**Lancashire
Constabulary**

Planning Ref 3/2012/0927

Title.
PROPOSED PLAN & ELEVATIONS
SCHEME 2

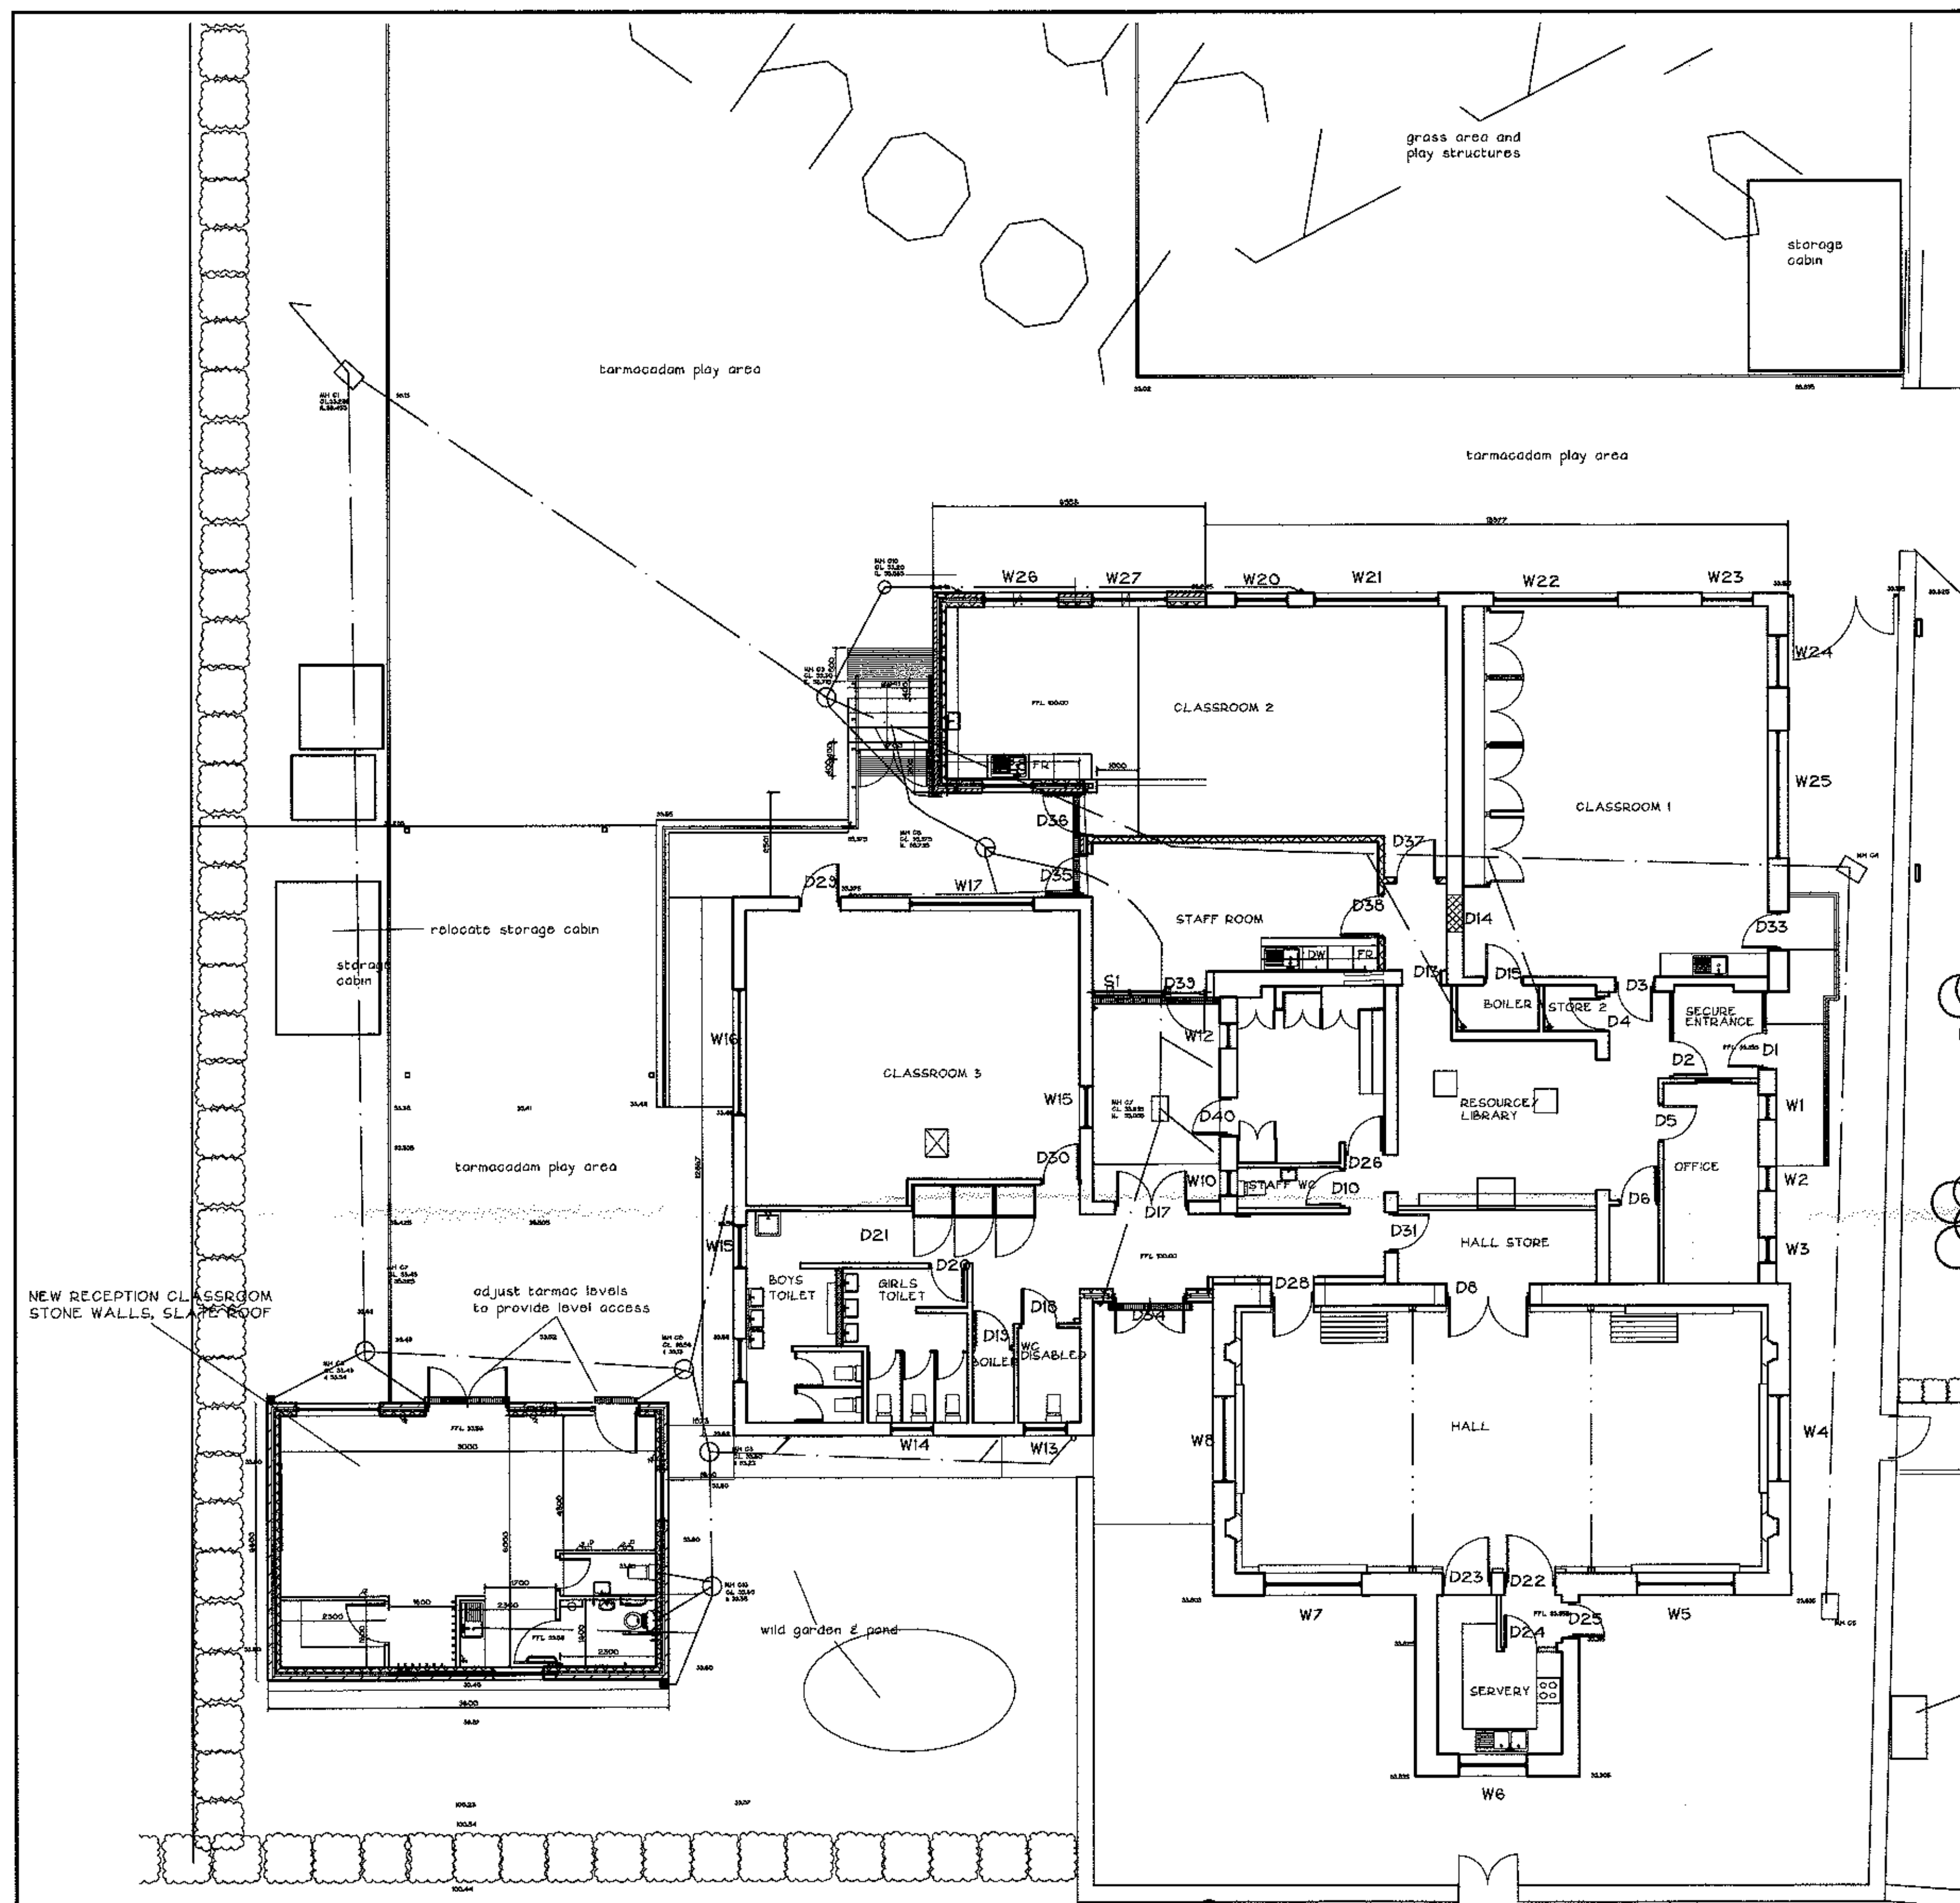
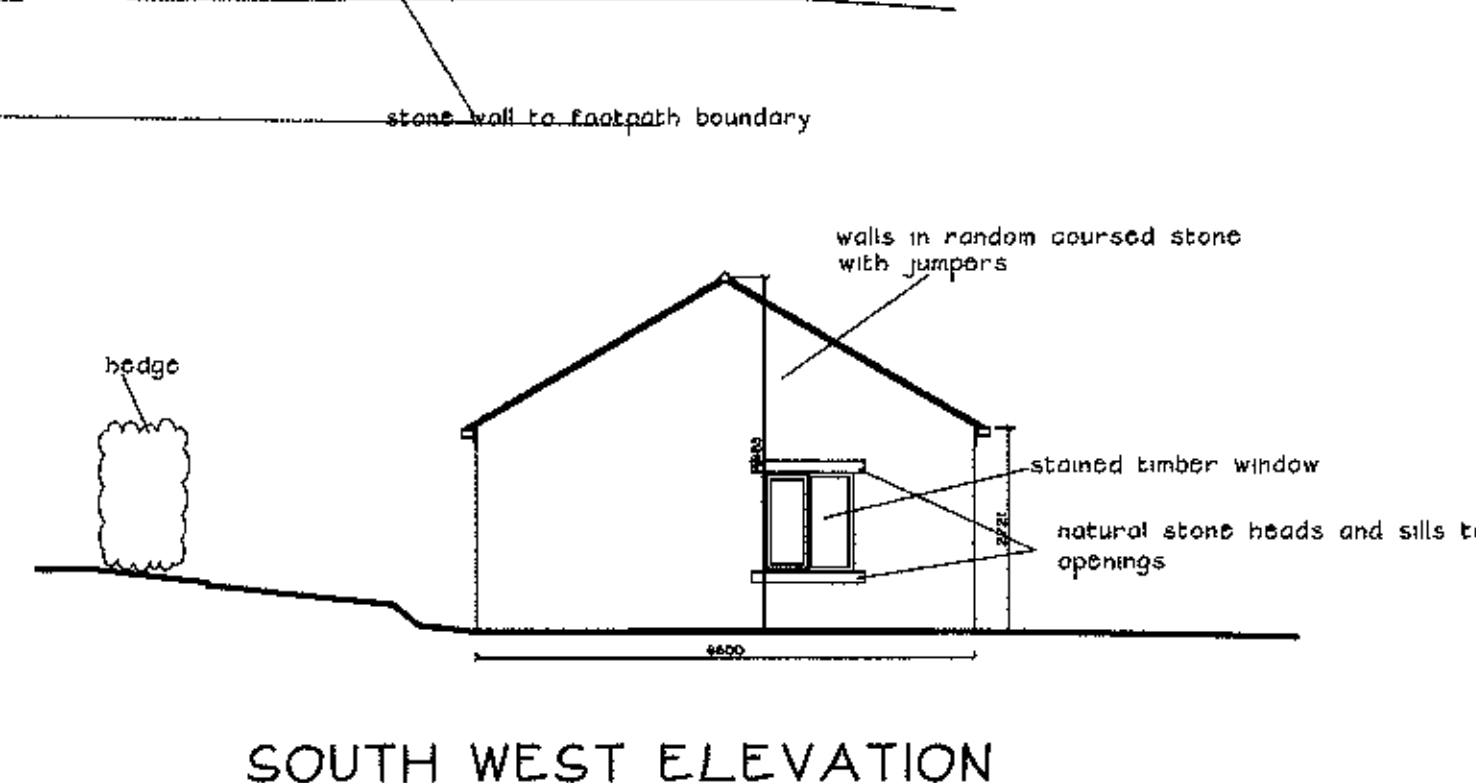
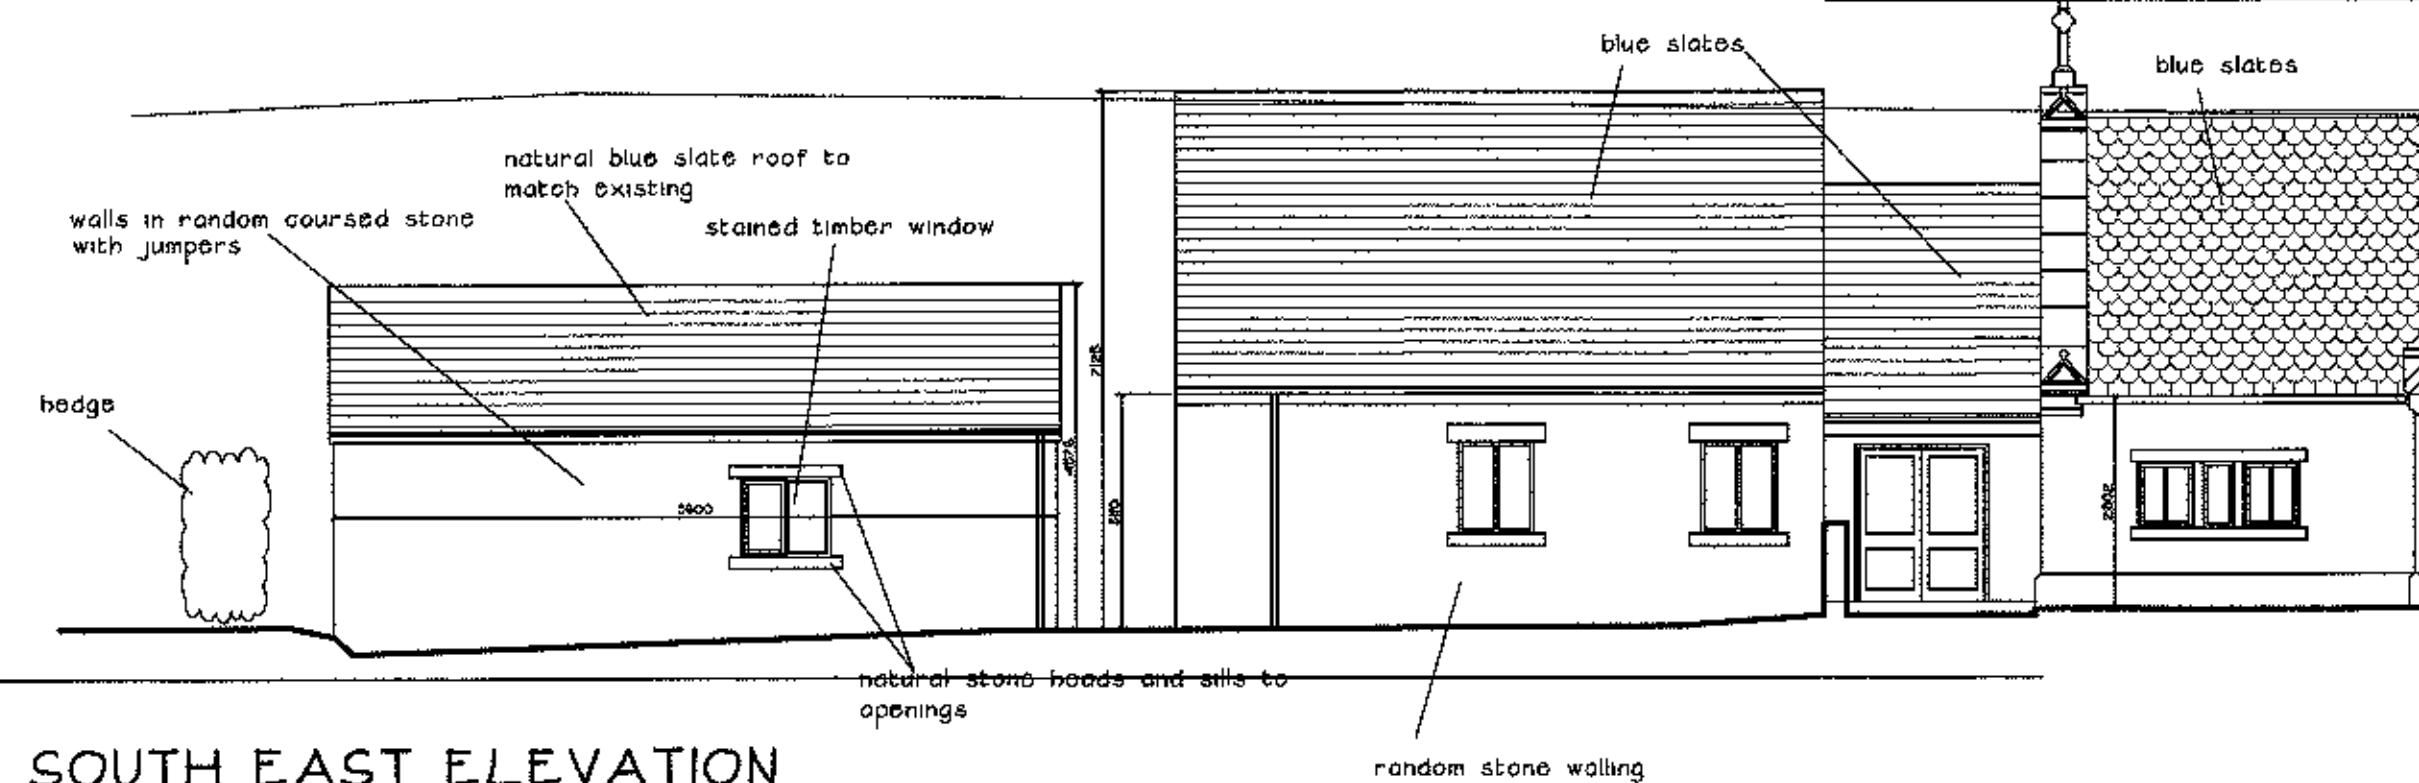
As this building is not part of the main school building, consideration should be given as to how the alarm system would link up to the main school alarm. The windows should meet British Standard 7950, should be laminated or toughened glazing and be fitted with restrictors which prevent them being opened beyond a small amount from the outside. The external door sets should meet PAS 24, this means that it has been tested against regular forms of intruder attack.

Electronic access control should be considered to prevent unauthorised access.

If the site currently has a CCTV system, it should be extended to cover the new building.

Internal storage should be considered for locking away valuables, out of sight – not seen from windows and doors.
